Recommendation Report for Planning Permission for Works or Extension to a Dwelling

REF NO: WA/36/19/HH

LOCATION: Holly Tree Cottage
The Street
Walberton
BN18 0PH

PROPOSAL: Proposed first floor rear extension (Resubmission of WA/101/18/HH). This application affects the character and appearance of Walberton Village Conservation Area.

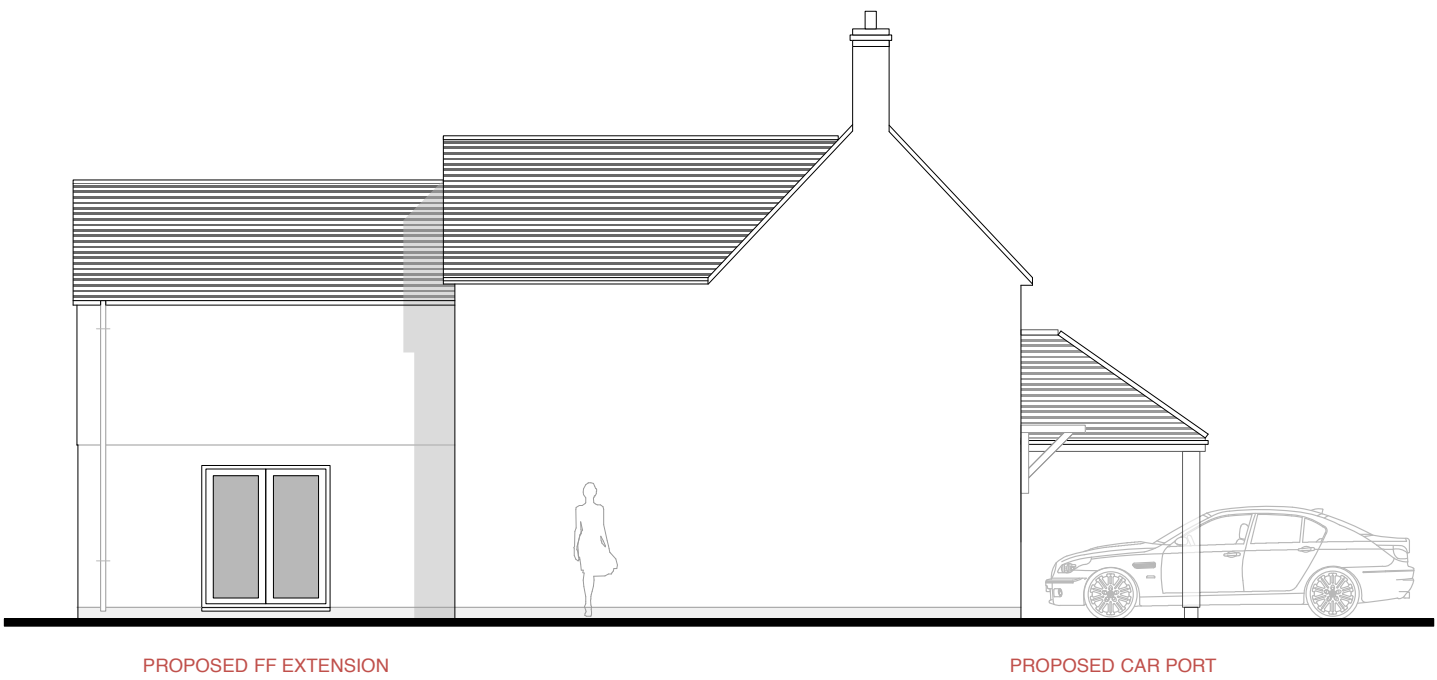
The extension is situated to the rear of the property and as such is not visible from the street scene. The extension will have a gable roof and with existing gables to the rear of the dwelling, the development is considered to appear well integrated. With it also set lower than the existing it also appears subservient. Materials identified within the Design and Access Statement are to match the host dwelling.

An additional first floor window will be constructed to the rear which will look over the rear garden of the host dwelling and may give rise to views towards the rear window at the neighbouring property situated to the north east, however any overlooking is not considered significant with the property sited at an angle to the host dwelling and separation at 15m with trees also in place at the boundary.

2 additional windows will also be sited at first floor facing east. With the side elevation of The Holly Tree Pub located at this elevation, it is not considered to result in adverse overlooking. There will be doors to

CLIENT	Mr & Mrs J Waights	SCALE	1:100 @ A3
SITE	Holly Tree Cottage, The Street, Walberton	STATUS	PL / LBC
PROJECT	Proposed First Floor Extension	AUTHOR	AH
DRAWING	001 Existing & Proposed Floor Plans	DATE	23 04 19

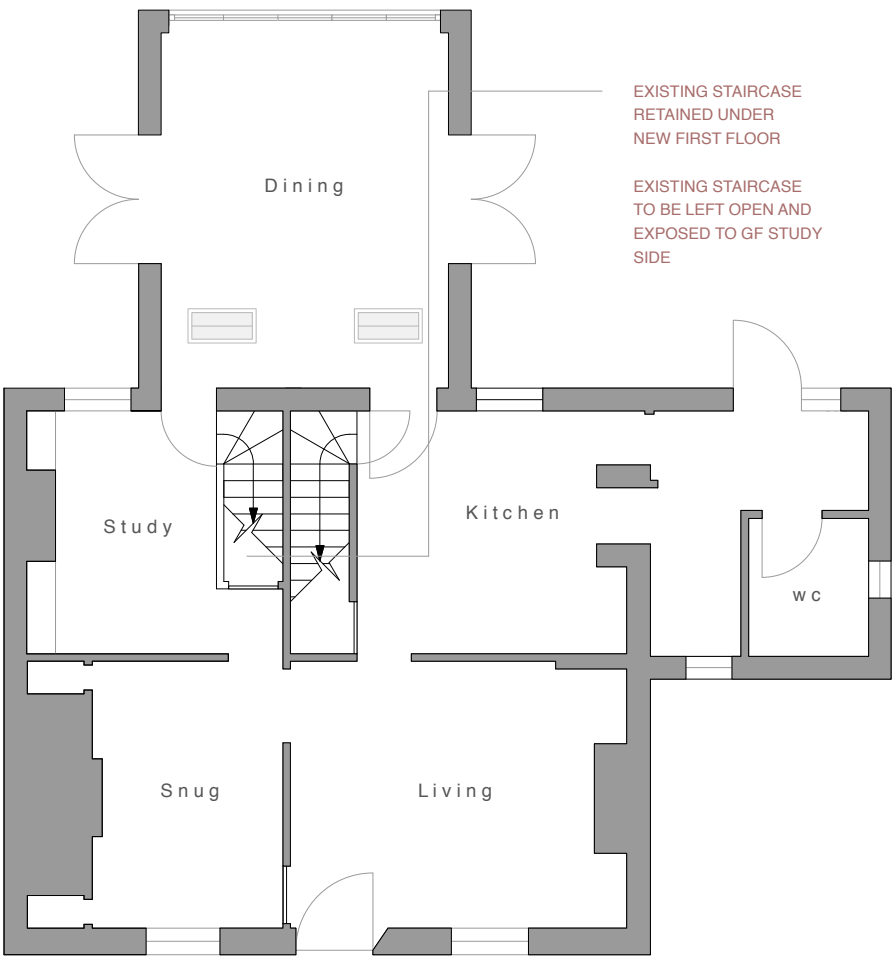
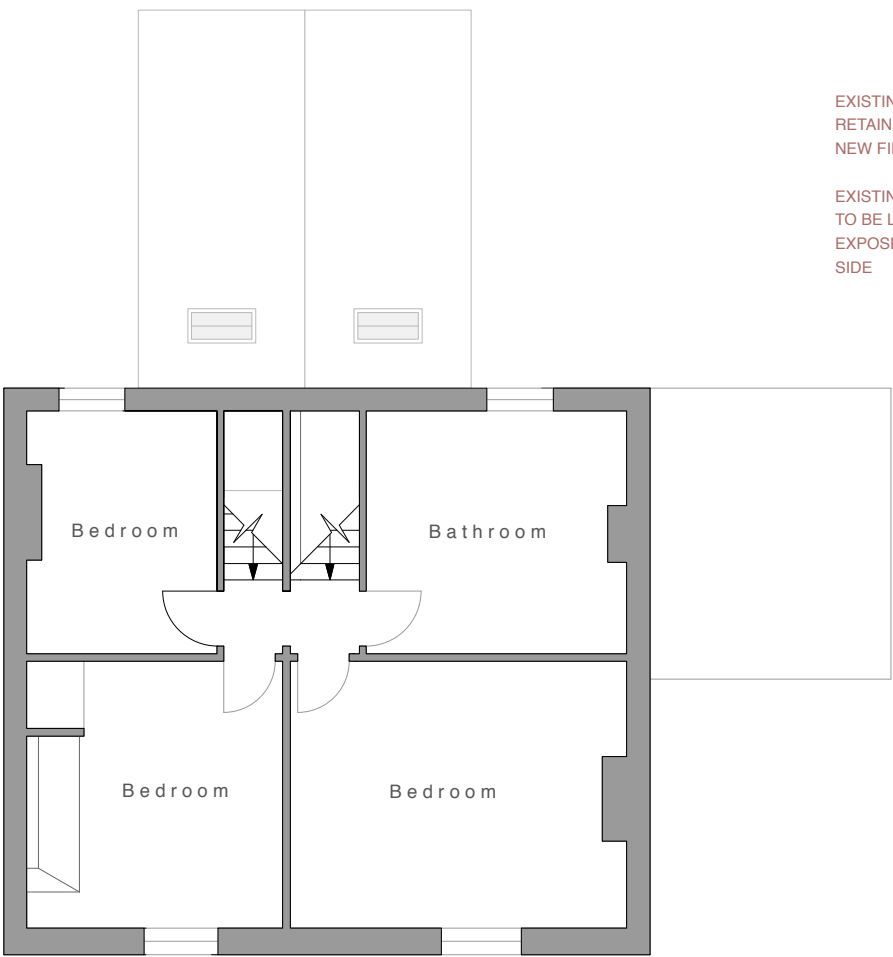
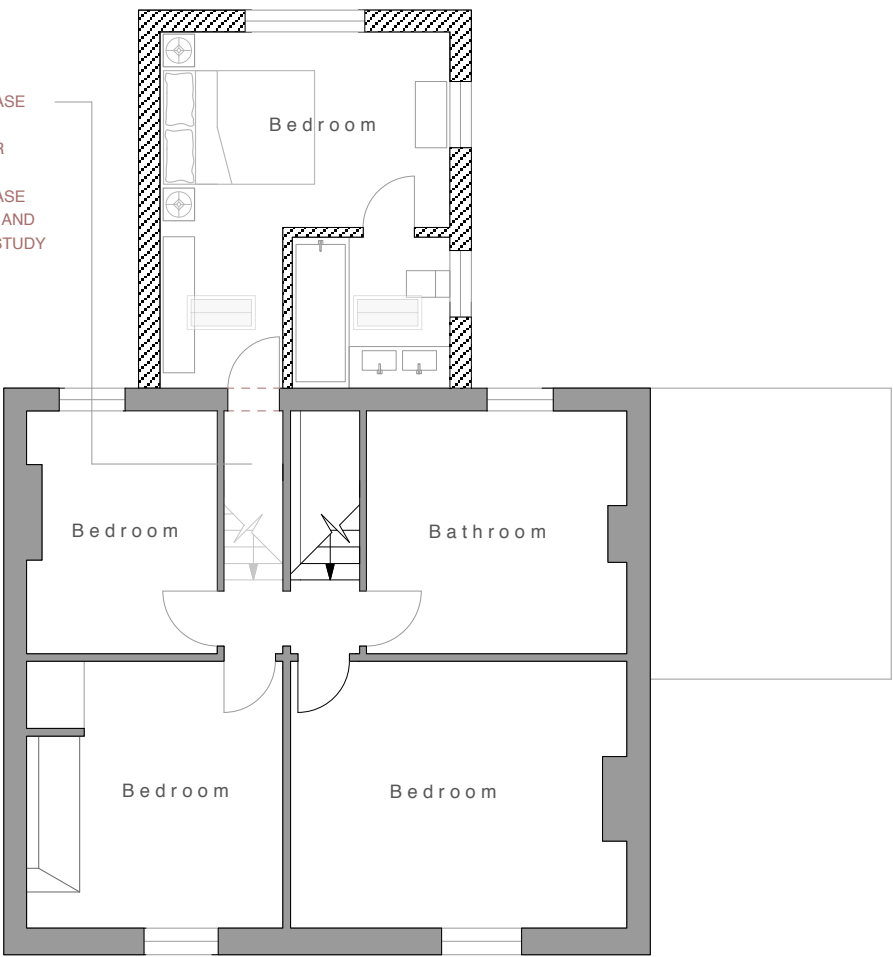
The rear extension is somewhat subservient to older parts of the building. The proposal would result in the loss of one of the existing staircases which is linked to when the house was two properties. This would result in loss of historic fabric and could harm the significance of the cottage. The garage would be dominant and highly visible.

Following these comments the garage was removed from the application and the staircase is to be retained.

Revised plans show the removal of the carport. This is positive and reduces the harm to the Listed building and Conservation Area. The staircase will be retained with flooring inserted on top, which will ensure the stairs remain. On balance the revised proposal will not harm the significance of the heritage assets or their setting.
